Re: Australian Museum – Alterations and additions (SSD 9452) Notice of Exhibition

I refer to your letter dated 22 October 2018 inviting comments on the above State Significant Development for alterations and additions at the Australian Museum located at 1 William Street, Sydney, in the City of Sydney local government area. The subject site is listed on the State Heritage Register as the Australian Museum (SHR 00805) and is located in the vicinity of various other SHR items listed on the State Heritage Register.

LONG SECTION - LOOKING NORTH
1:200

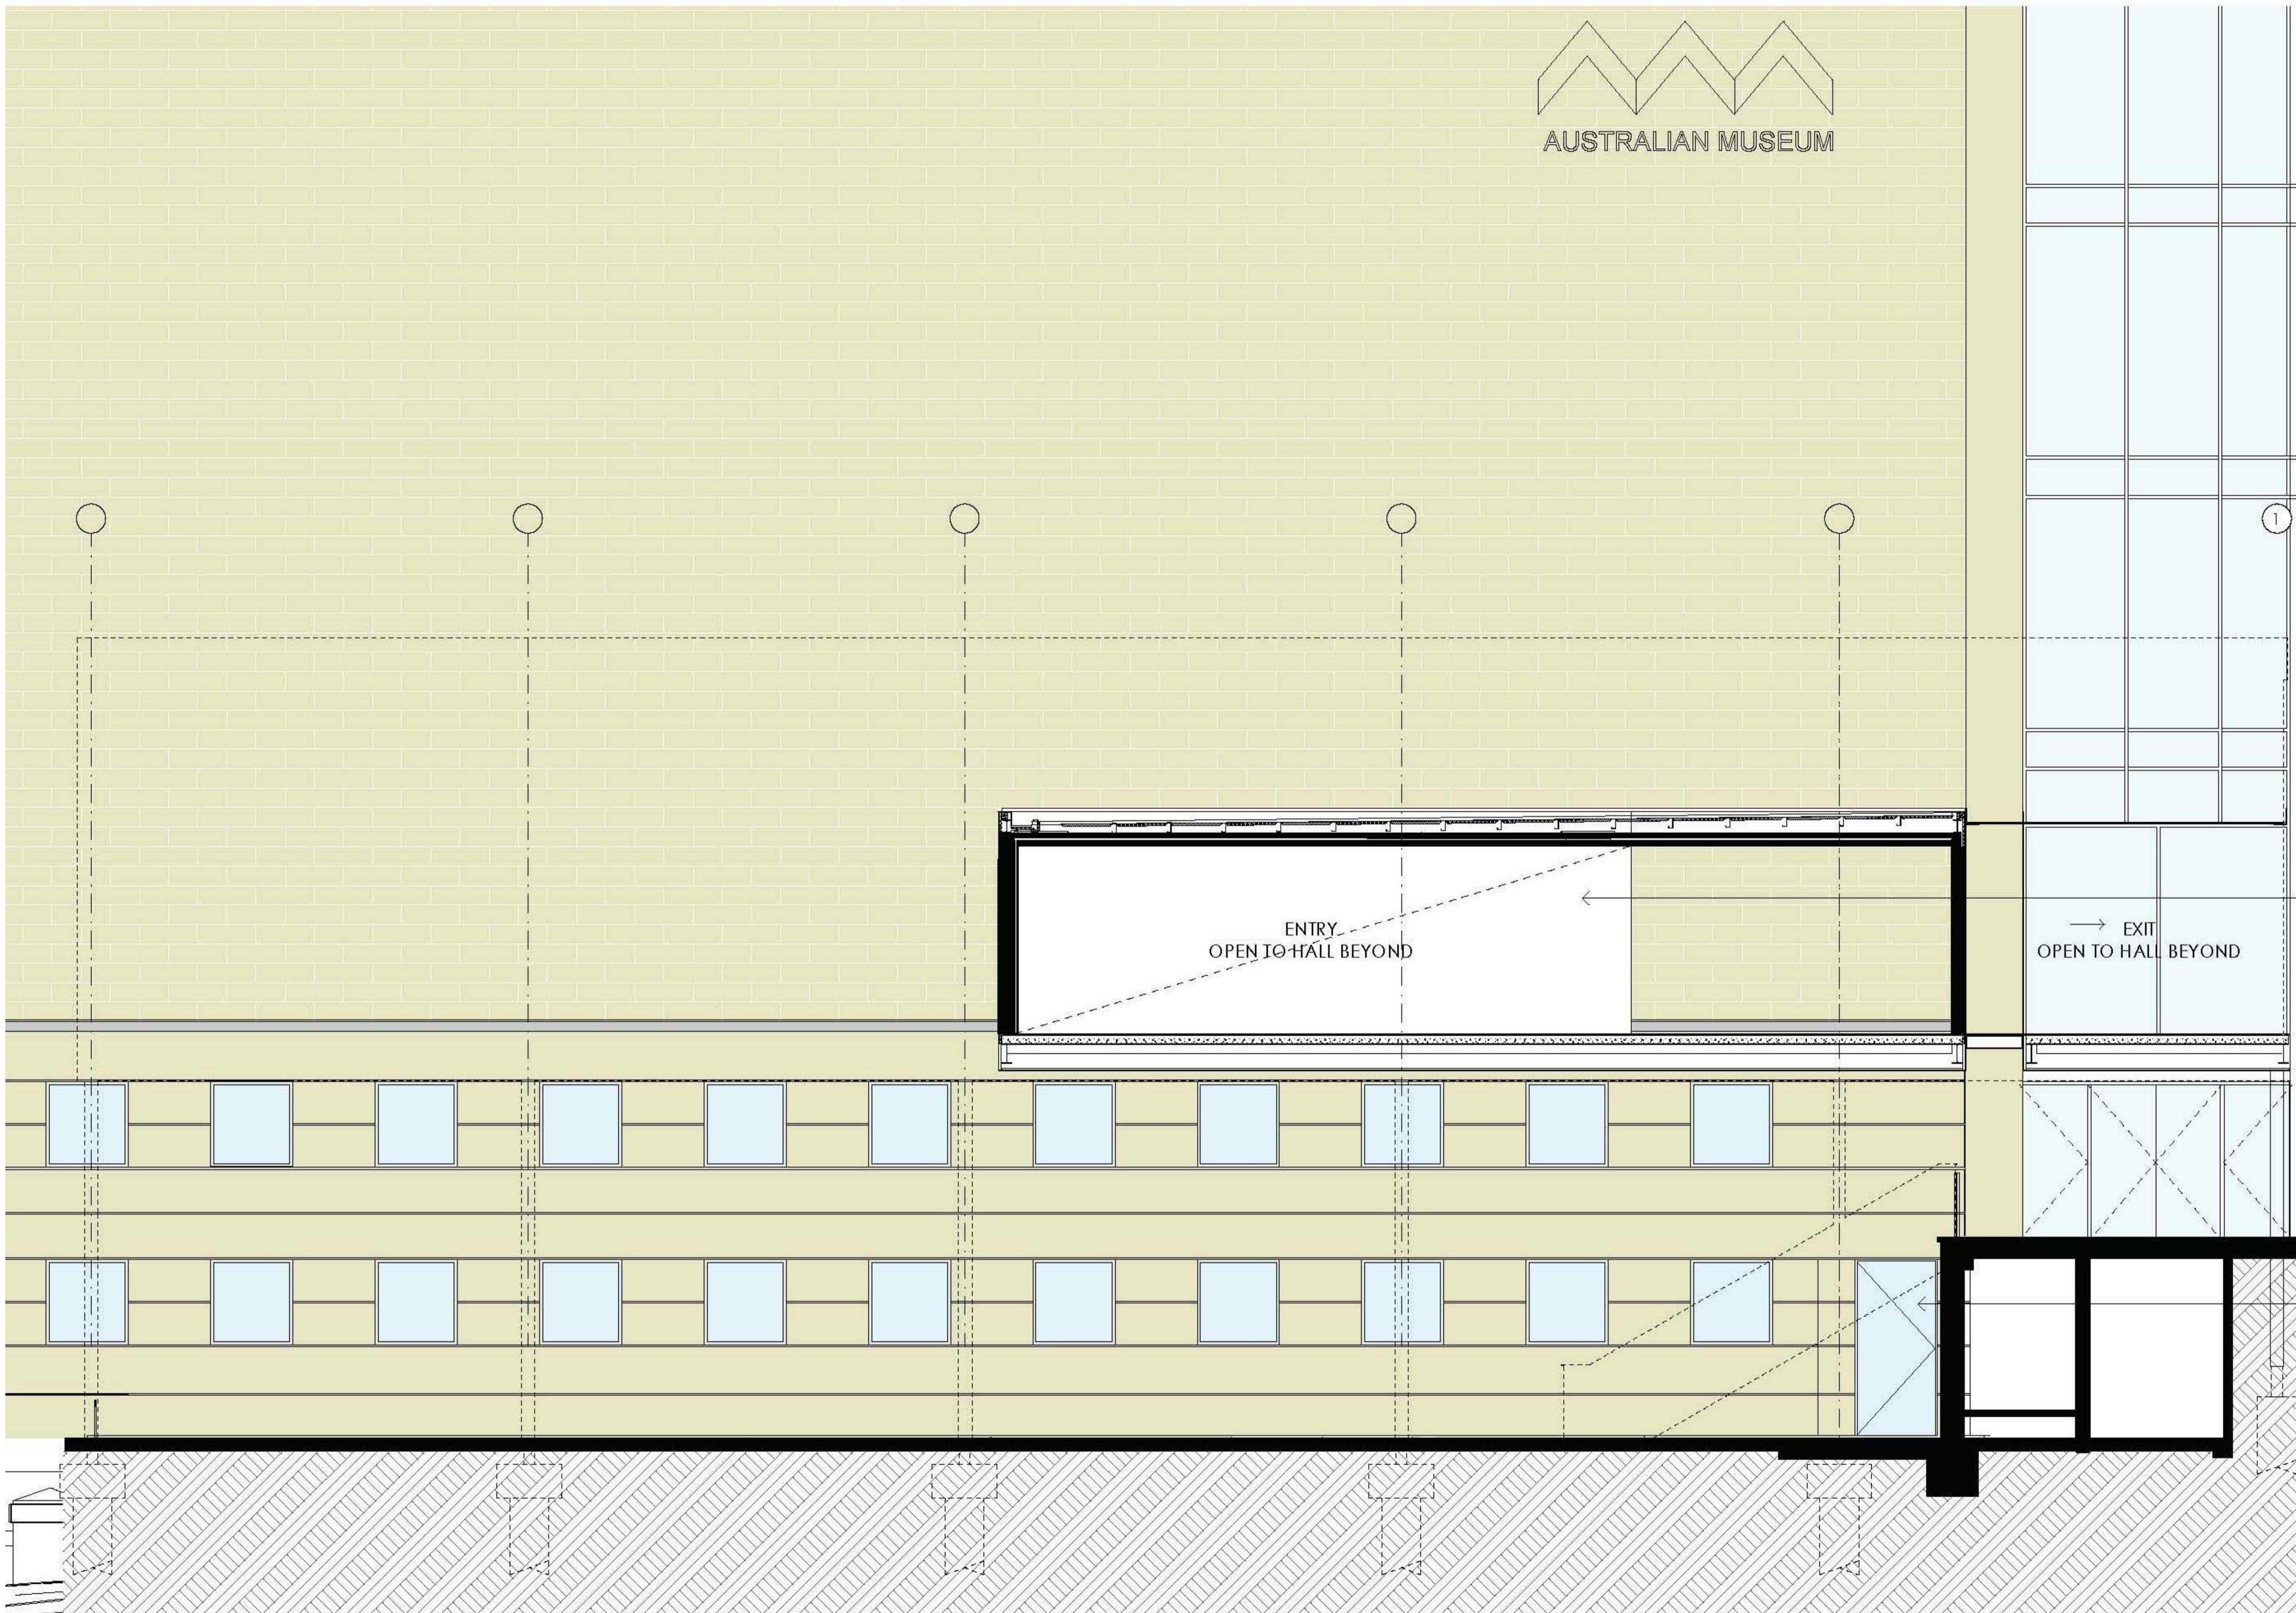
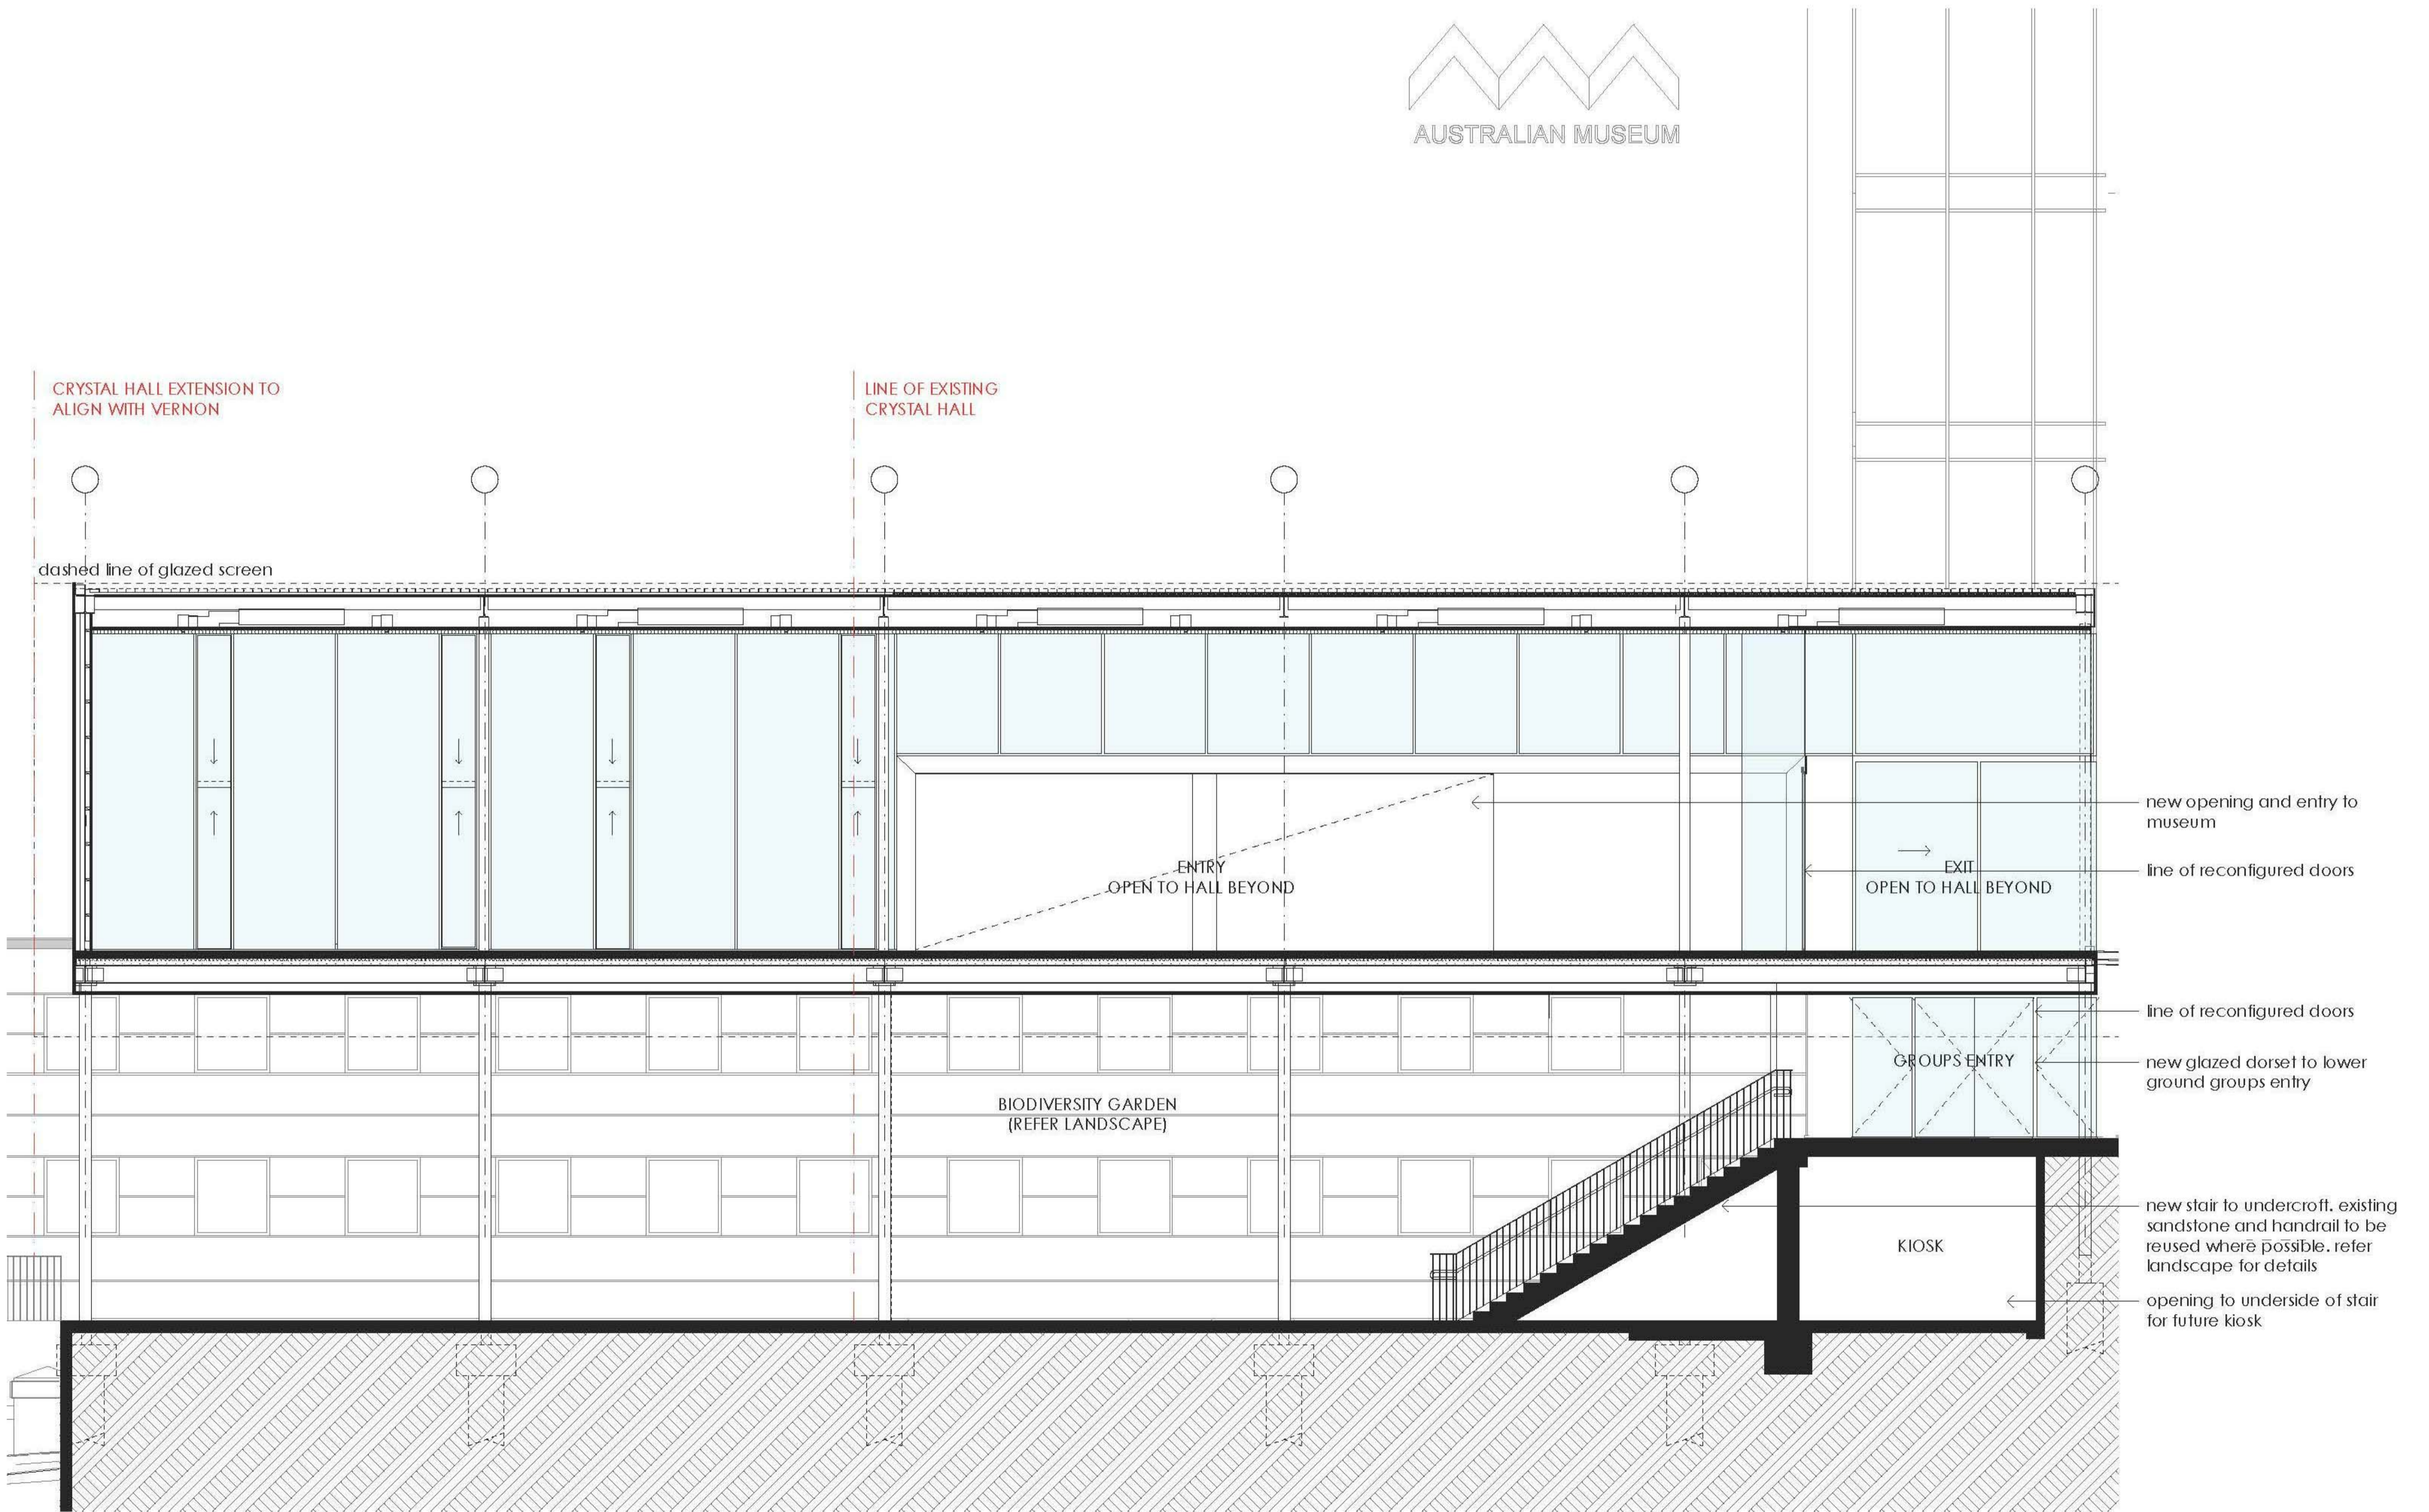
- Consideration should be given, and a methodology prepared to re-use the external stairs of 'medium' significance located north of the Parkes Farmer wing in the construction of the new stair configuration (re-oriented from an east-west to a north-south axis).

- Detailed design for the following aspects of the scope should incorporate measures to minimise heritage impacts and be prepared in consultation with the nominated heritage consultant: new plant room against the rear façade of Barnet wing's lower ground floor; new raised floor along the rear facade of Lewis wings' ground floor; new ramp against the rear façade of Vernon wing's ground floor; rebuilding of lightwell roof
